SUBJECT: Monument Ridge East
RE: Traffic Impact Study
Response to Comments Memorandum
LSC #S234450

Following are the LSC Transportation Consultants, Inc. responses to the November 8, 2024 comment posted to EDARP regarding SP241.

Traffic Review

Figure 3  
Proposed Realignment  
of Monument Hill Rd  
and Extension of  
Misty Acres Blvd

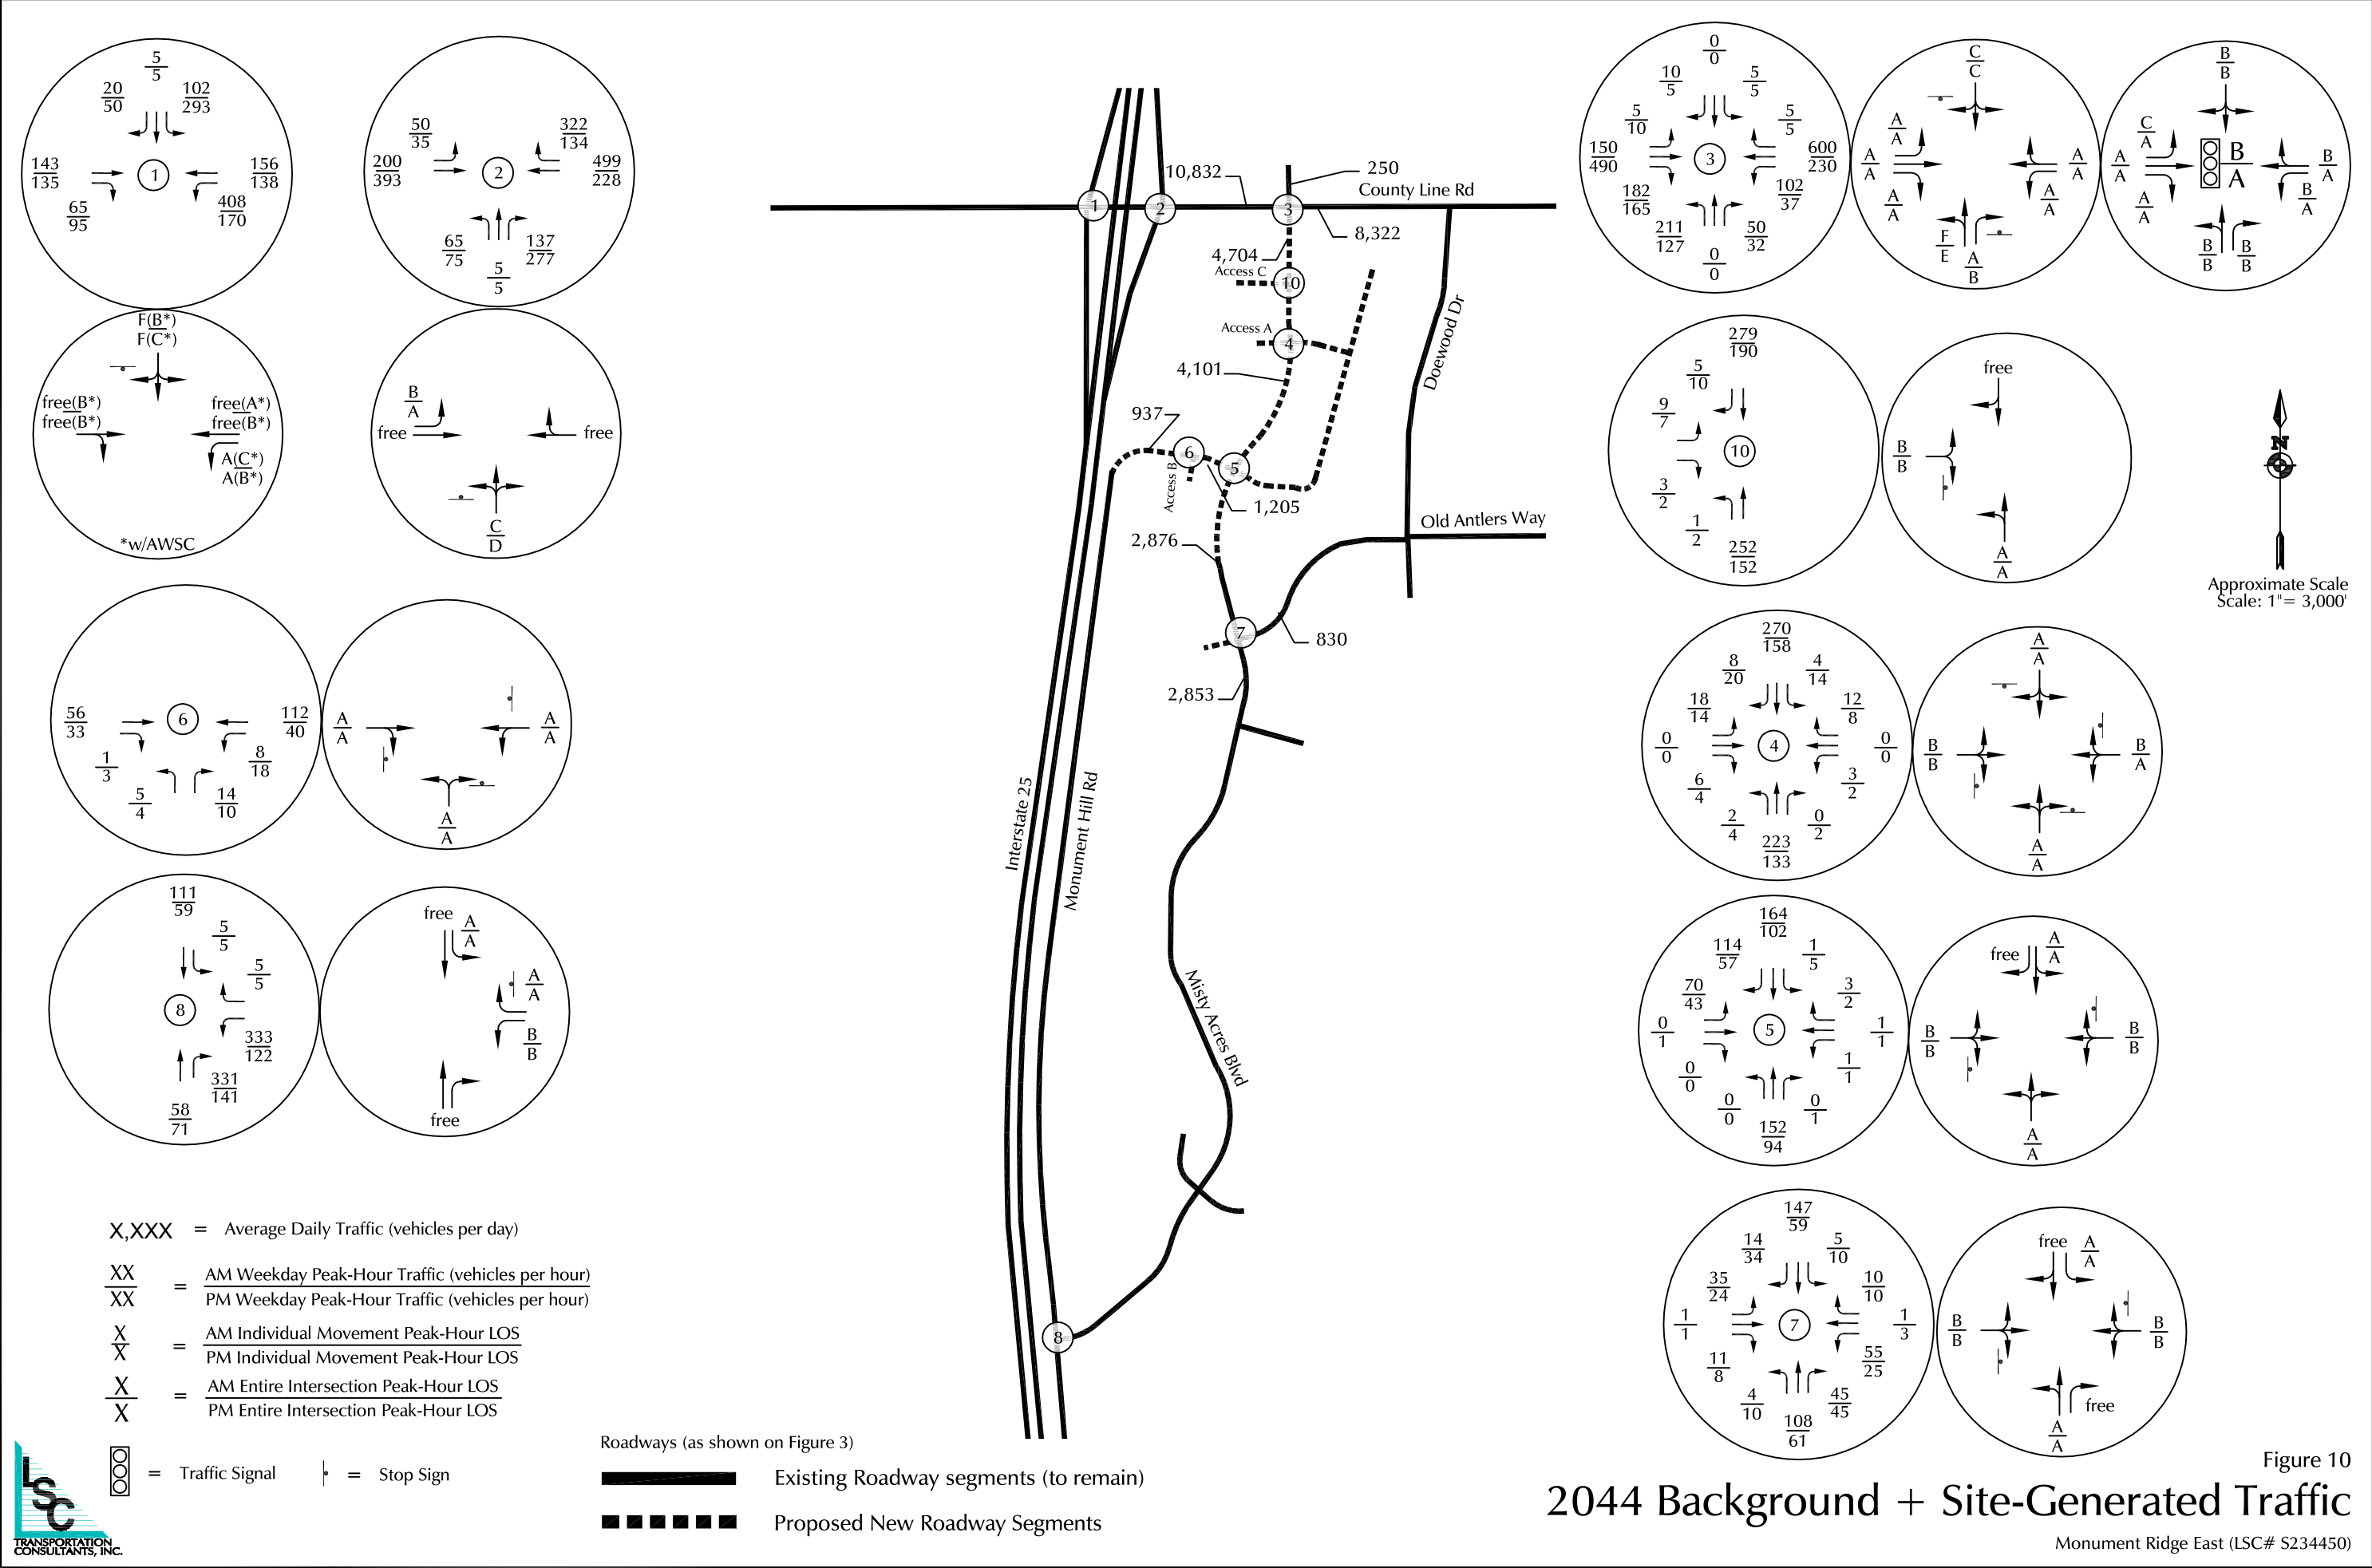
a. *All comments have been addressed. The only correction for the TIS that is needed is that CDOT would not be taking an escrow for NBR at the NB off-ramp. Rather, we will require the construction of the NBR lane at buildout by the Monument Ridge East developer. The reimbursement would probably be an option from the future developments, such as the Travel Center in the SW corner of the interchange. You will need to coordinate with the County on this topic.*

LSC Response: This paragraph has been revised as requested.
